CITY OF ALBUQUERQUE

July 25, 2022

RE: Slim Chicken
8240 Montgomery Blvd NE
Grading and Drainage Plans
Engineer's Stamp Date: 07/05/21
Hydrology File: G19D004E

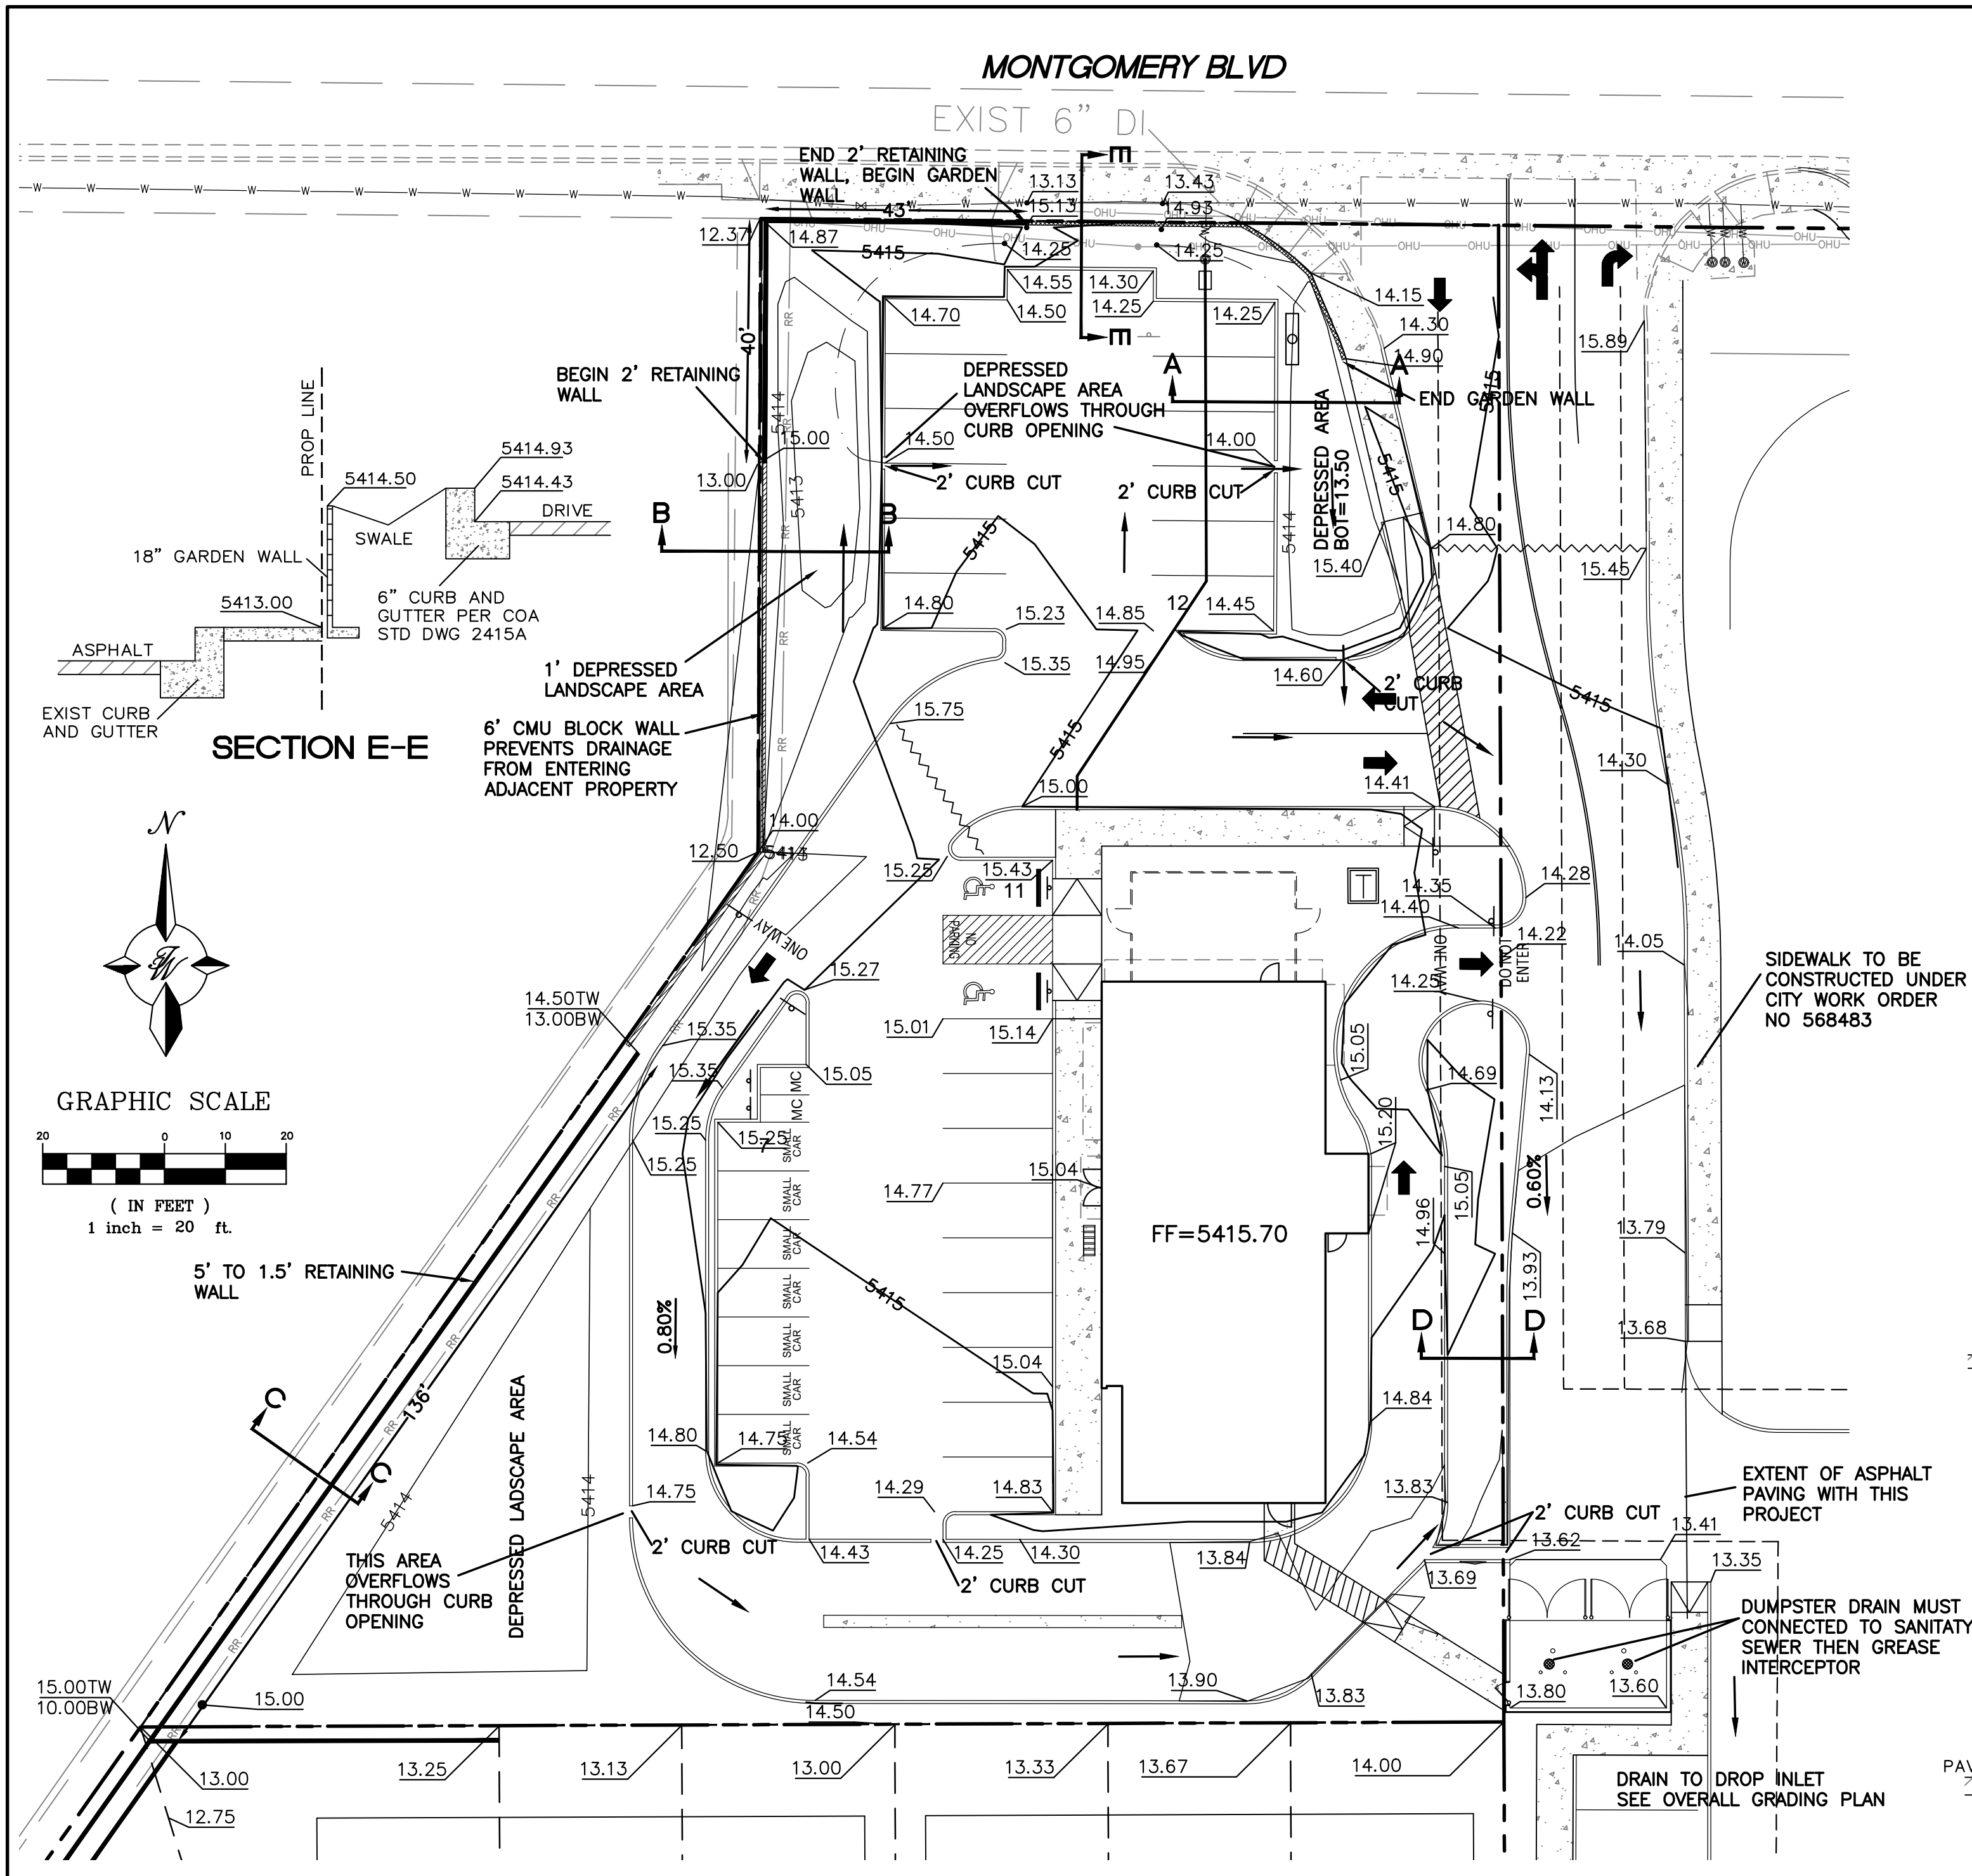
1. The retaining wall along Montgomery needs to be labeled as such in Section E-E. This also needs to show an L shaped footer within the property.

2. There is still issues with the whole parking area by Montgomery drainage. Where is this area discharging to? The two ponds don't appear to go anywhere and this will trap standing water & mosquitoes when it rains. This area may just drain over the block wall to the southwest and drain onto the adjacent property which is not allowed. Another

issue is that the depressed areas are not needed since this Tract is covered by the overall development's Stormwater Quality Pond to the south next to La Mirada Place.

- Trash enclosures must demonstrate control of liquids from dumpster areas per DPM by containing runoff from the dumpster area, preventing outside drainage from entering the dumpster area, and discharging to the sanitary sewer. Please show an inlet in the middle and label. "Inlet to be connected to the sanitary sewer. See Utility Plan."

- The low area in the Southwest corner has some drainage issues. Where is this area discharging to? The pond doesn't appear to go anywhere and this will trap standing water & mosquitoes when it rains. This area may just drain to the residential development to the south which is not allowed. Again there is an issue is that the depressed area which is not needed since this Tract is covered by the overall development's Stormwater Quality Pond to the south next to La Mirada Place.
